City of Gosford Design Advisory Panel

Meeting Agenda – Design Reference Group workshop

Details	
Name	City of Gosford Design Advisory Panel – Design Reference Group (DRG)
Location	Department of Planning and Environment (DP&E) 320 Pitt Street Sydney, Level 24 Blue Gum Room (meet in foyer)
Date/Time	Tuesday 30 th July 2019, 10:30am – 12:00pm
Chair	DRG member
Attendees	Robert Hodgkins (DP&E) Louise Starkey (DP&E) Paul Walter (DRG) Peter Smith (DRG) Johann Strey Anthony Kelly
Site	Gateway Shopping Centre, 237 Mann Street, Gosford

Northern Elevation - Faunce St Elevation

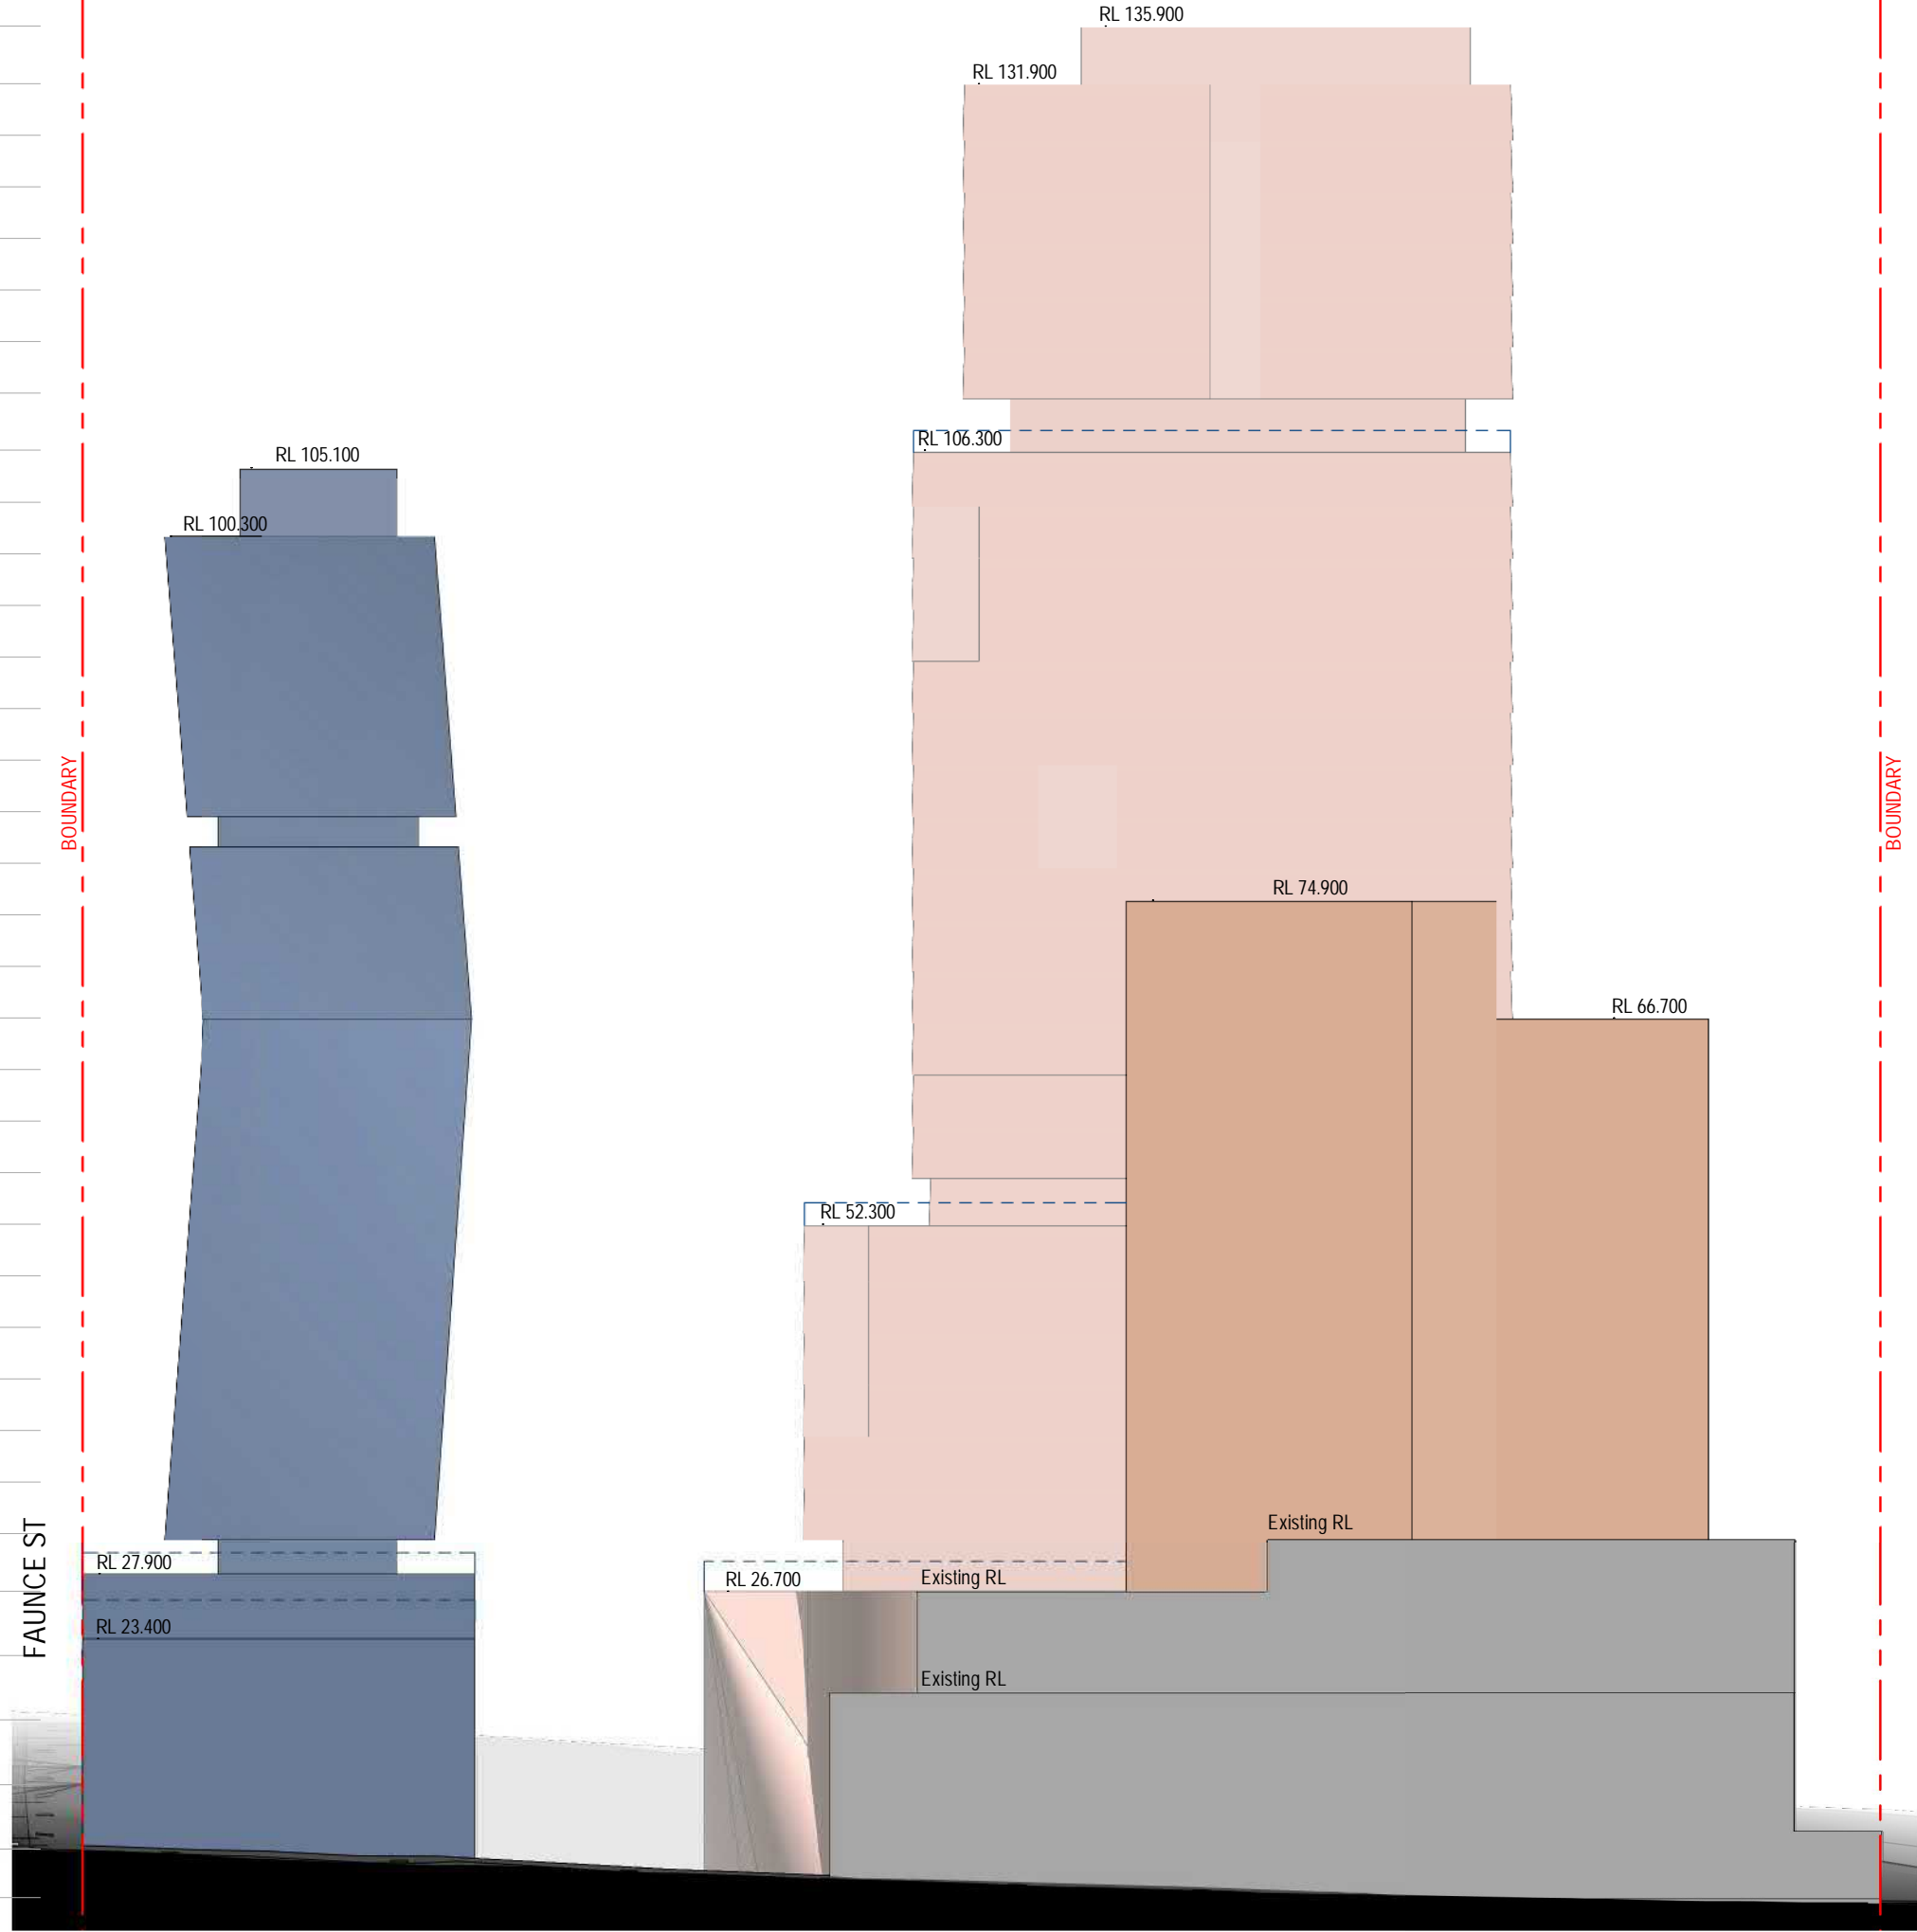
- Ensure the steeply sloping Faunce Street ground level is engaged and activated, along its length
- DRG also suggests the proponent explores the potential for a pedestrian/physical bridge link to the station/transport interchange, to the top of the podium and along the Faunce Street frontage and connecting to the Faunce Street RL

Internal Section A

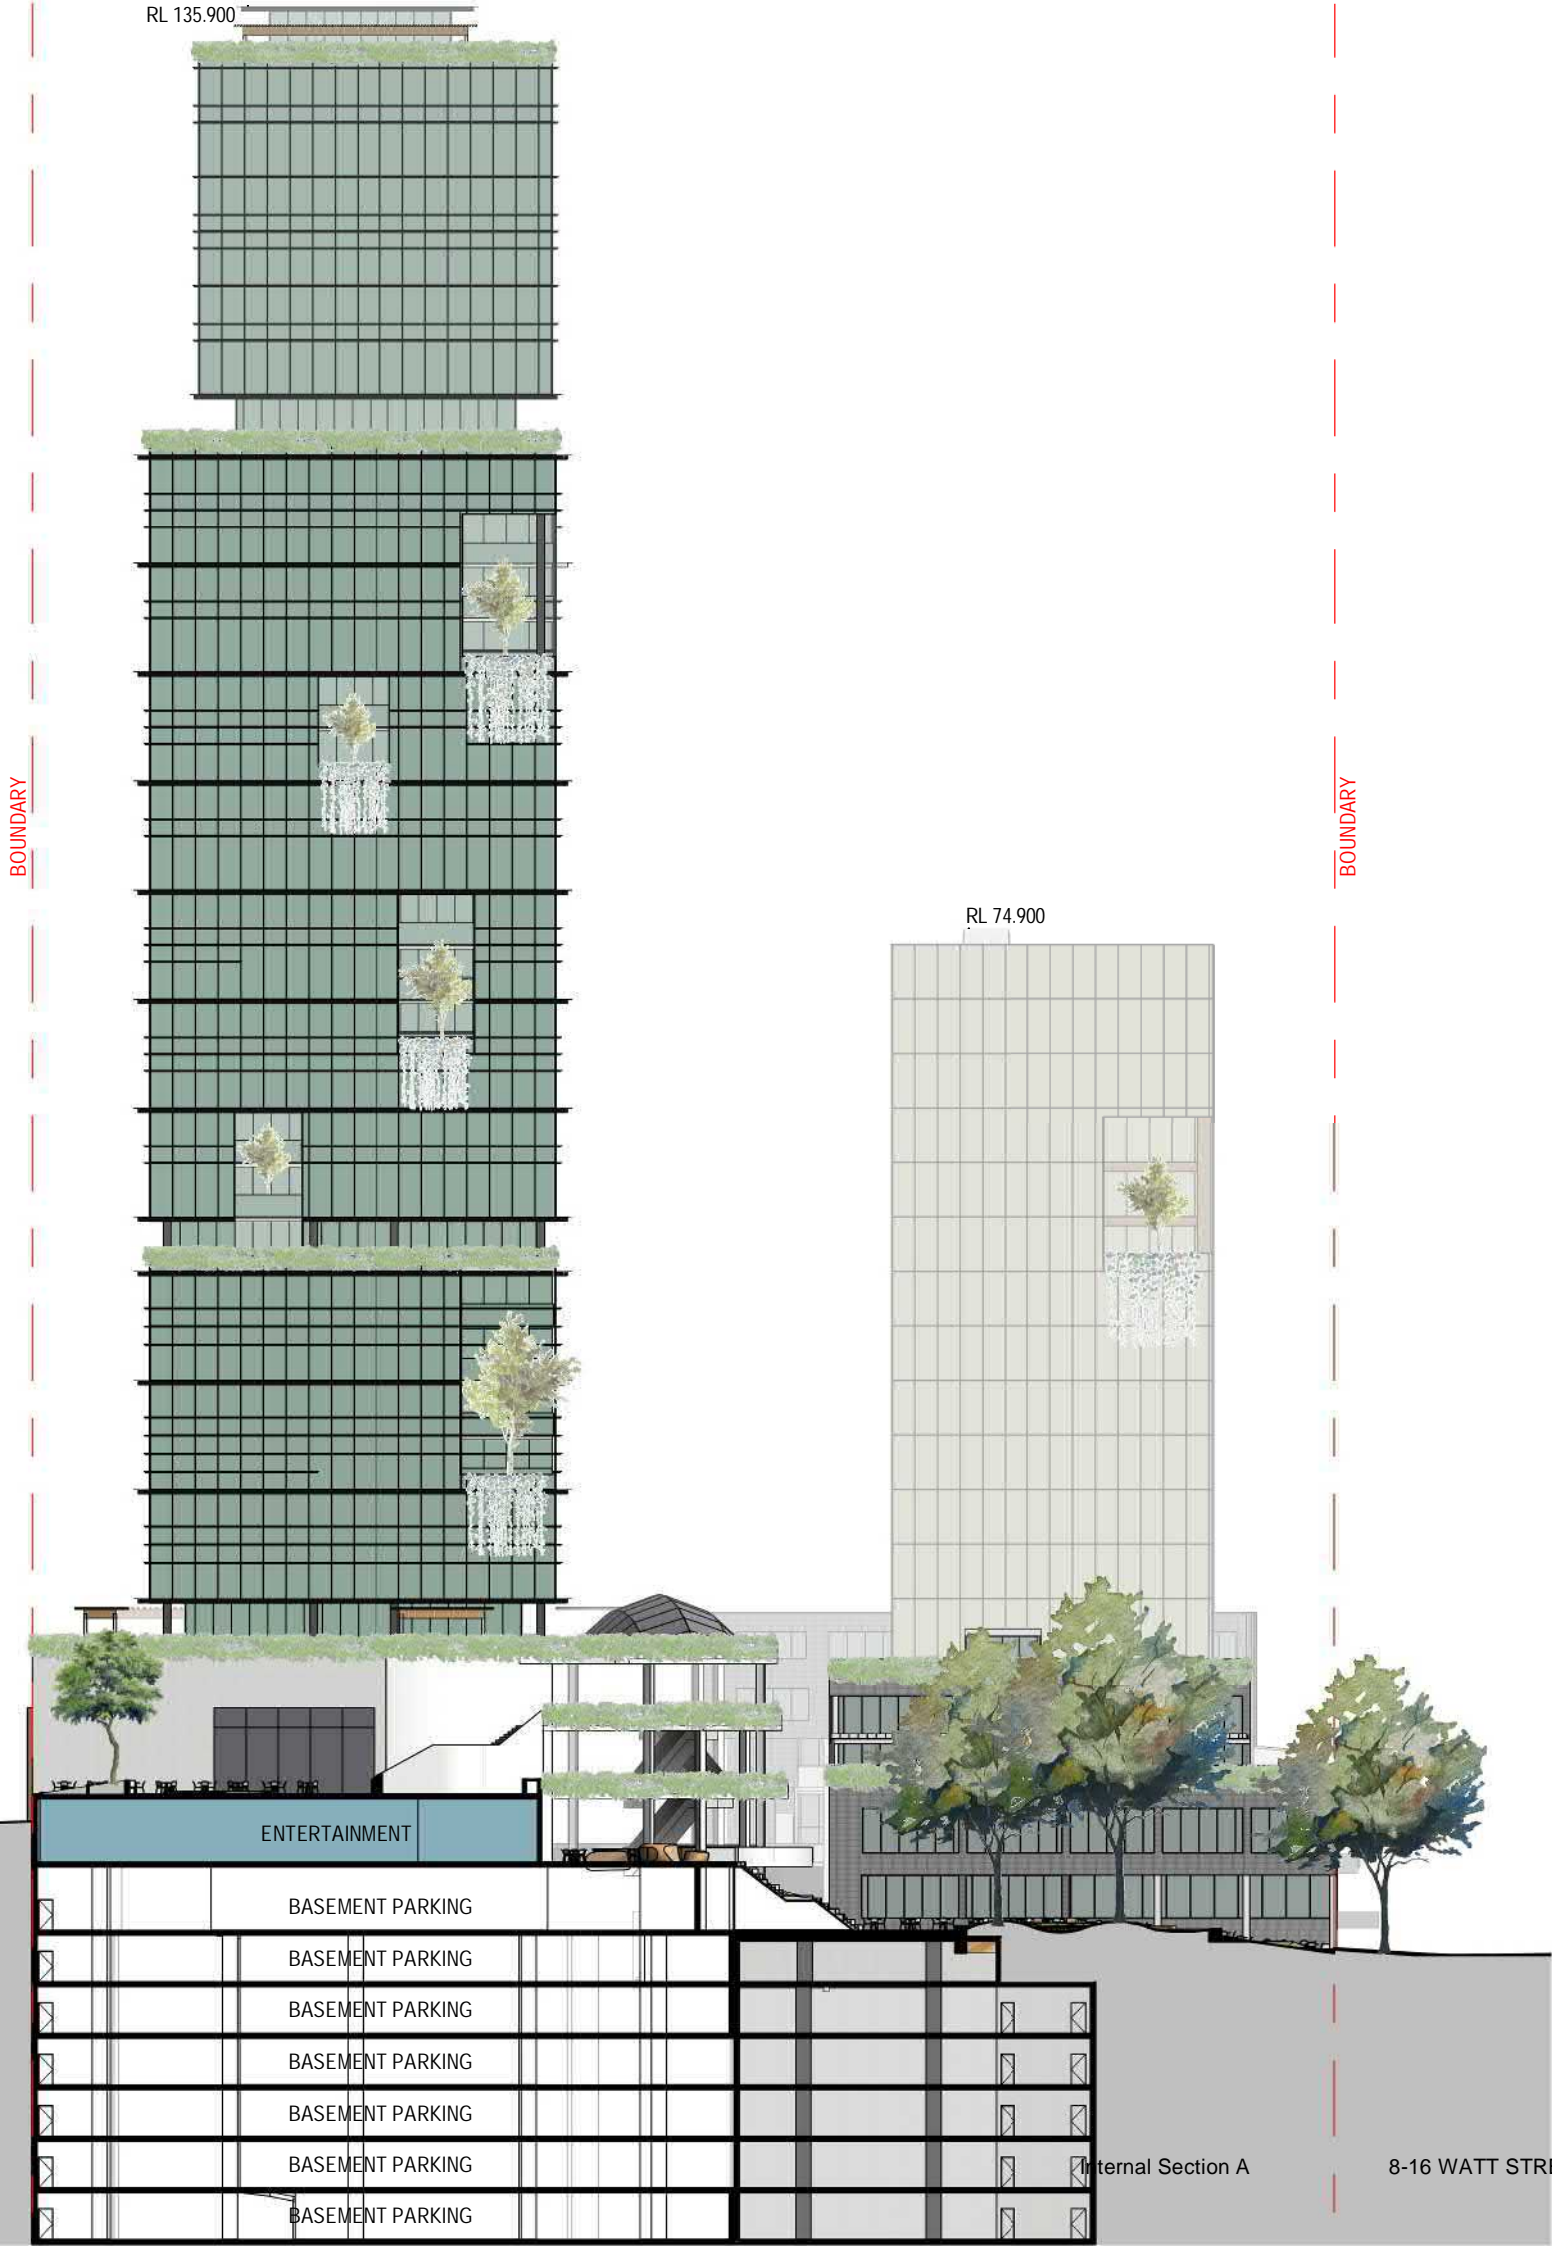
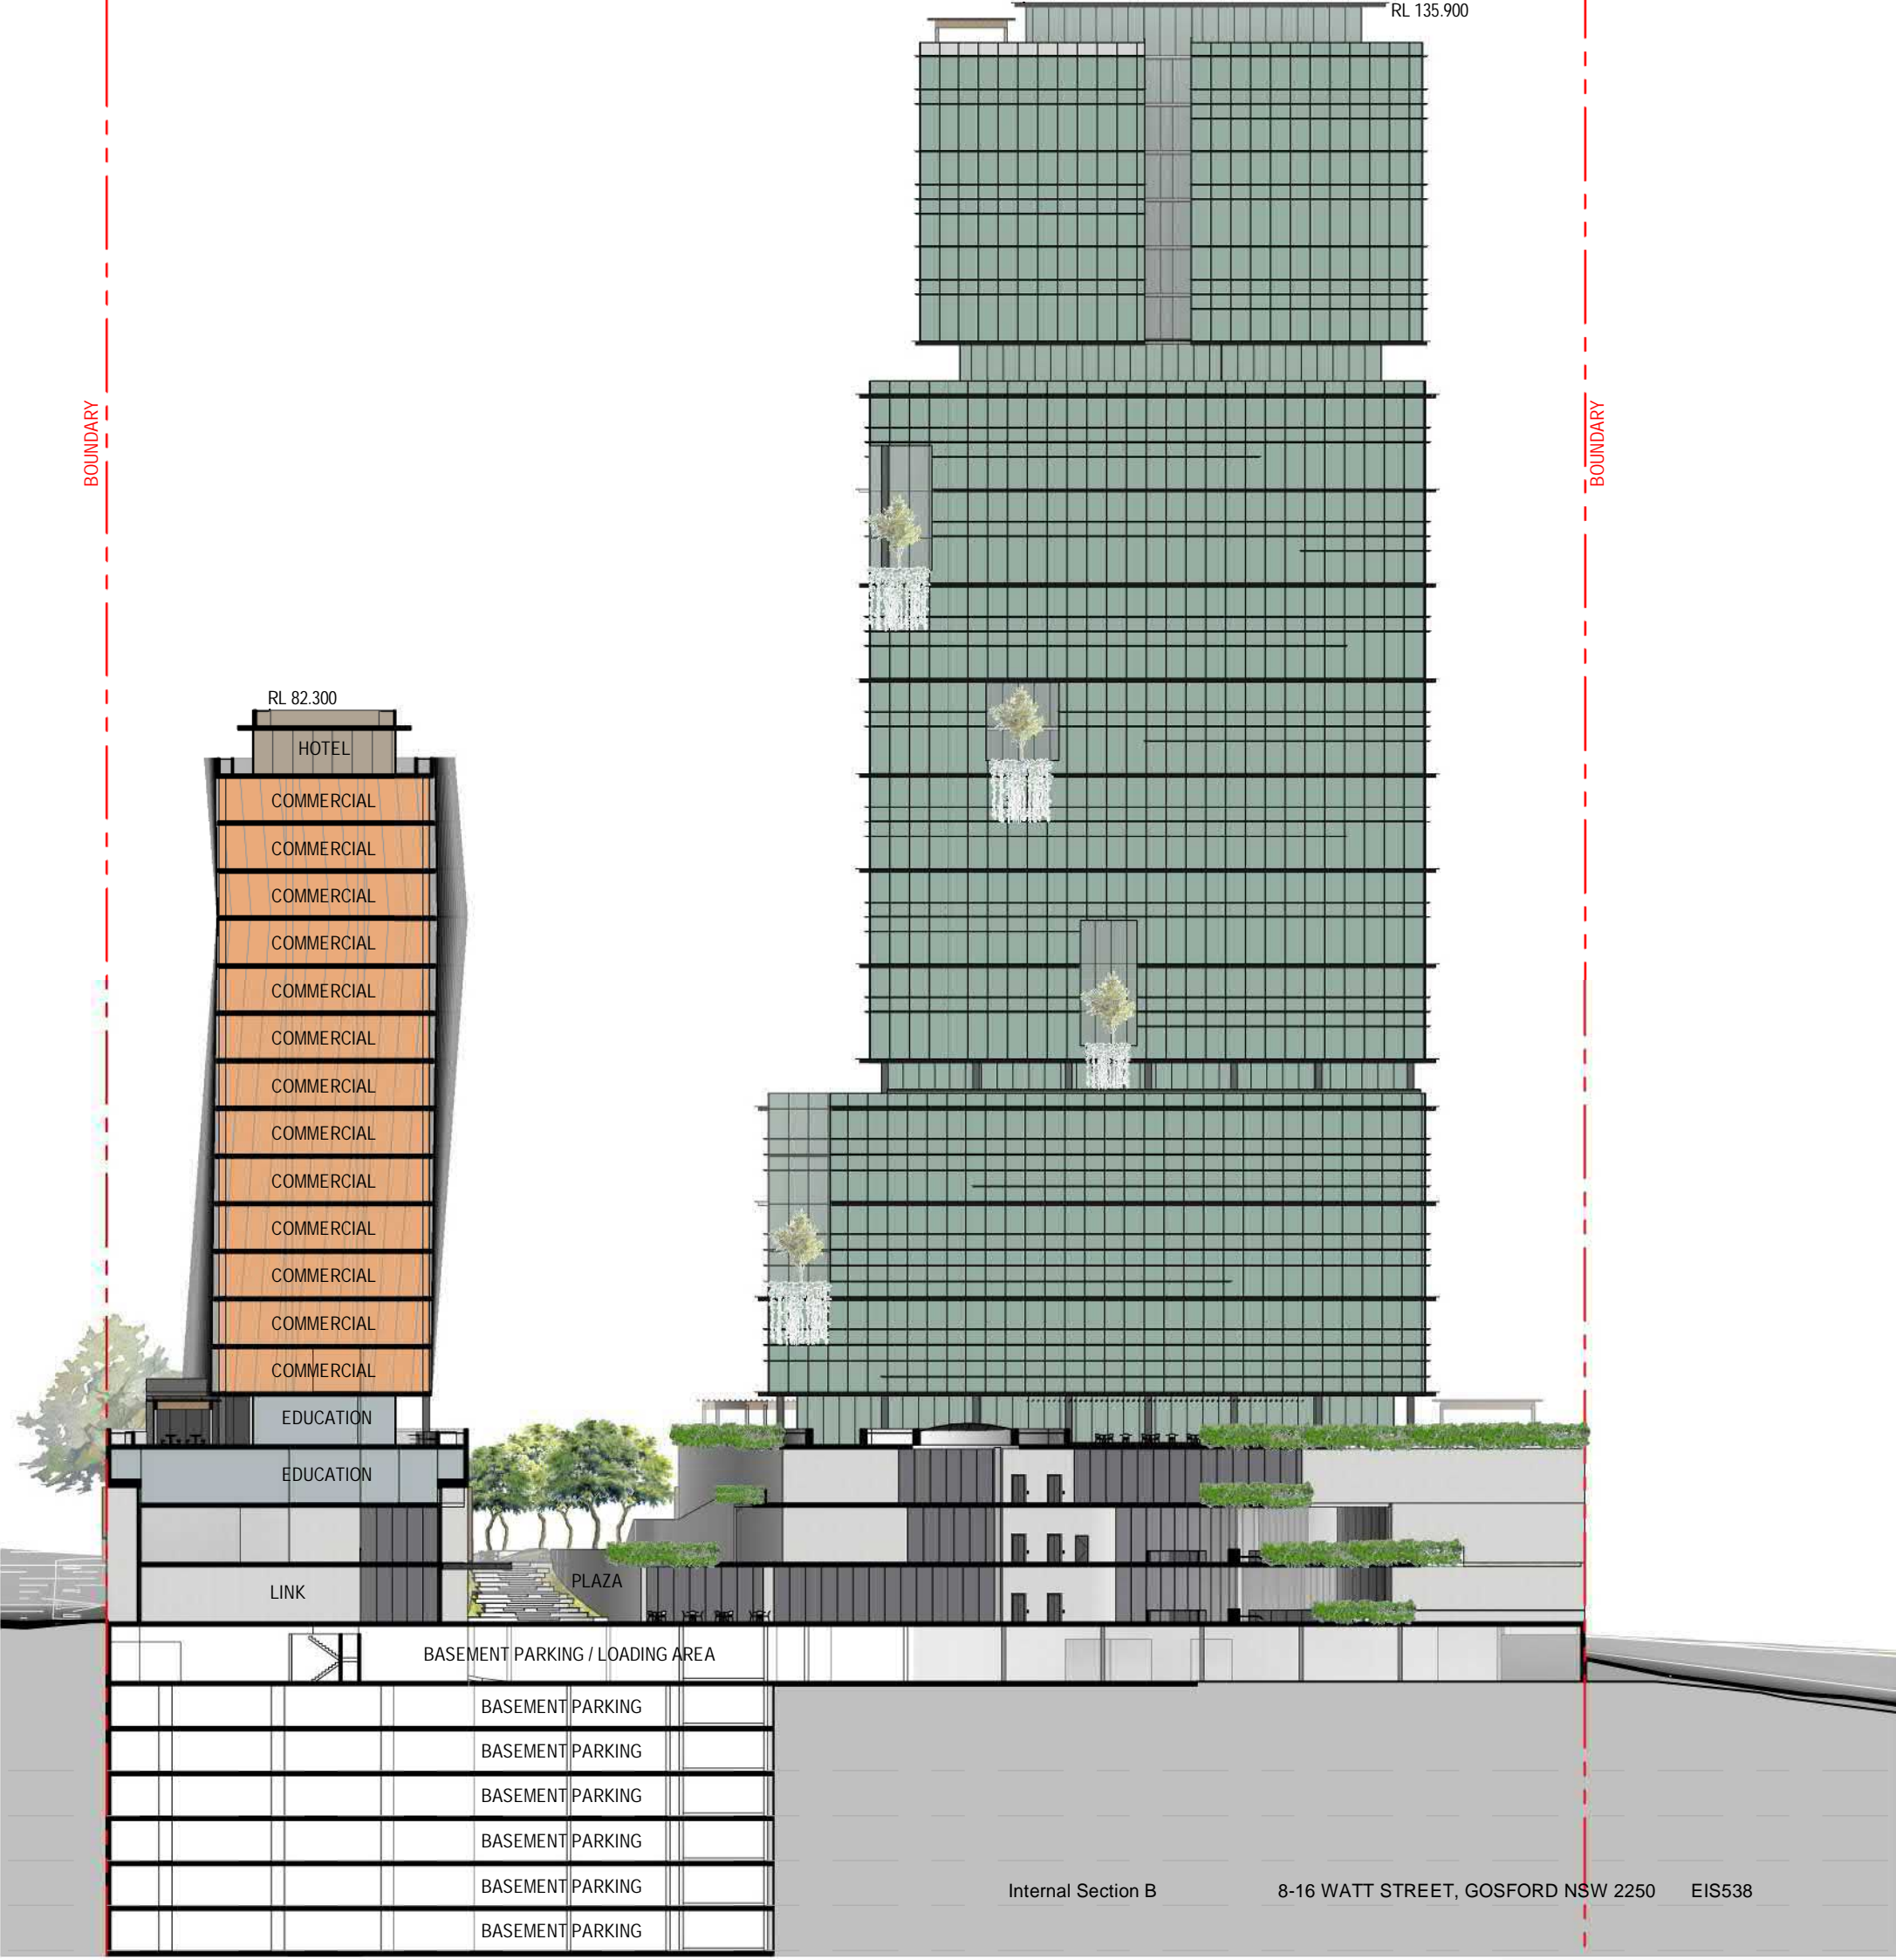
- Is there sufficient privacy separation between the student living and retirement,
- How does the shadow cast by the student housing impact solar access to the retirement
